Recommendation Report for Works to Tree(s) on trees subject to a Tree Preservation Order (TPO)

REF NO: A/100/21/T

LOCATION: Land to North of New Road
Angmering

PROPOSAL: Fell 12 No. Monterey Pine trees

Tree Area 1

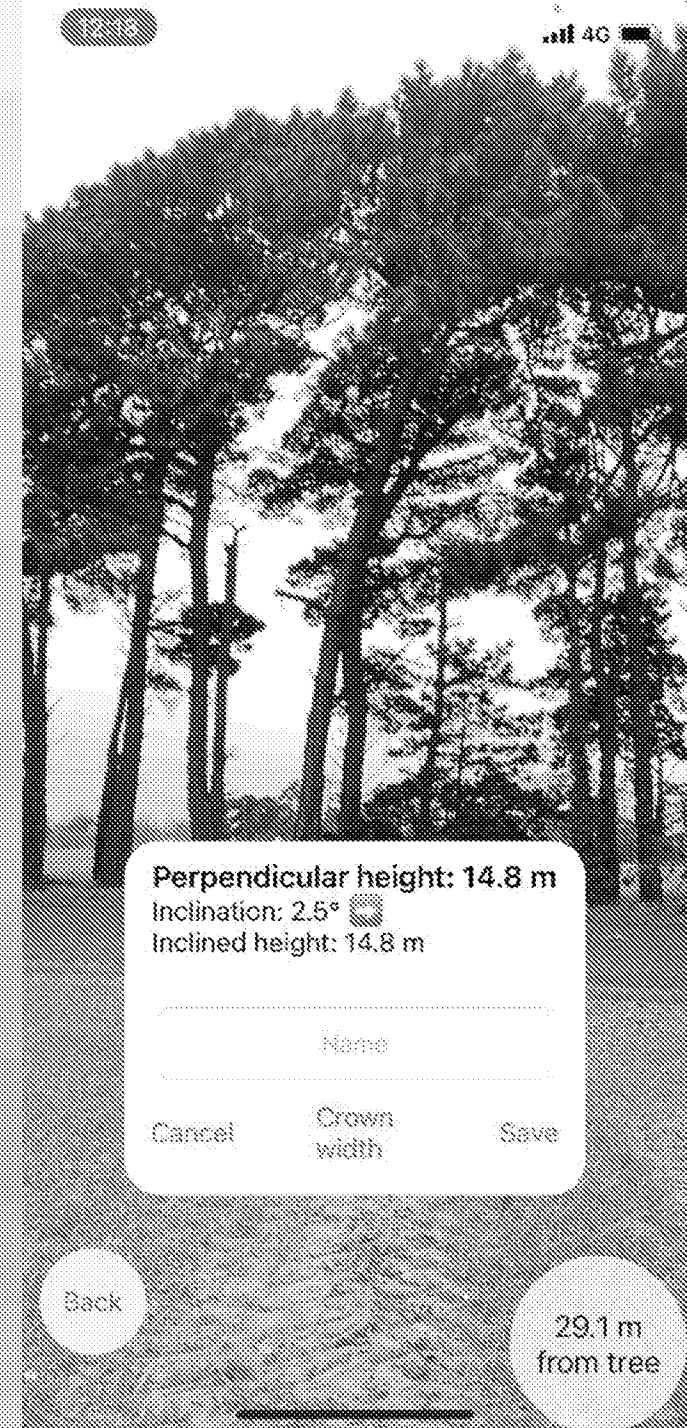
The age/class of trees within the group is variable, but dominant pine is early-/mature. Outwardly and from distance they appear to be in a fine physiological state (and assumed to be so in the absence of any information/evidence provided to the contrary).

These trees are important constituents of a long-established and prominent landscape feature. This broad belt of evergreen trees provides 230m of continuous high canopy, which provides great visual amenity.

Pine trees are intolerant of hard pruning and the extent of height reduction required to restore coverage to EE's existing mobile communications infrastructure would effectively destroy them. Subsequently we are dealing with an application to fell those trees to ground level. The essential provision of infrastructure by EE will be achieved through a combination of, upgrading its existing network, deploying more masts and building new sites.

The work proposal has not been justified on arboricultural grounds. These are high profile trees of significant landscape and visual amenity; whose value extends beyond their own individual worth; contributing to and benefiting from root and crown cohesion with the rest of the group.

Beyond the obvious and immediate impact to the landscape, suddenly exposing such aged trees to the full force of prevailing winds is likely to wreak havoc in their crowns from which they cannot recover and potentially resulting in further erosion of the group.
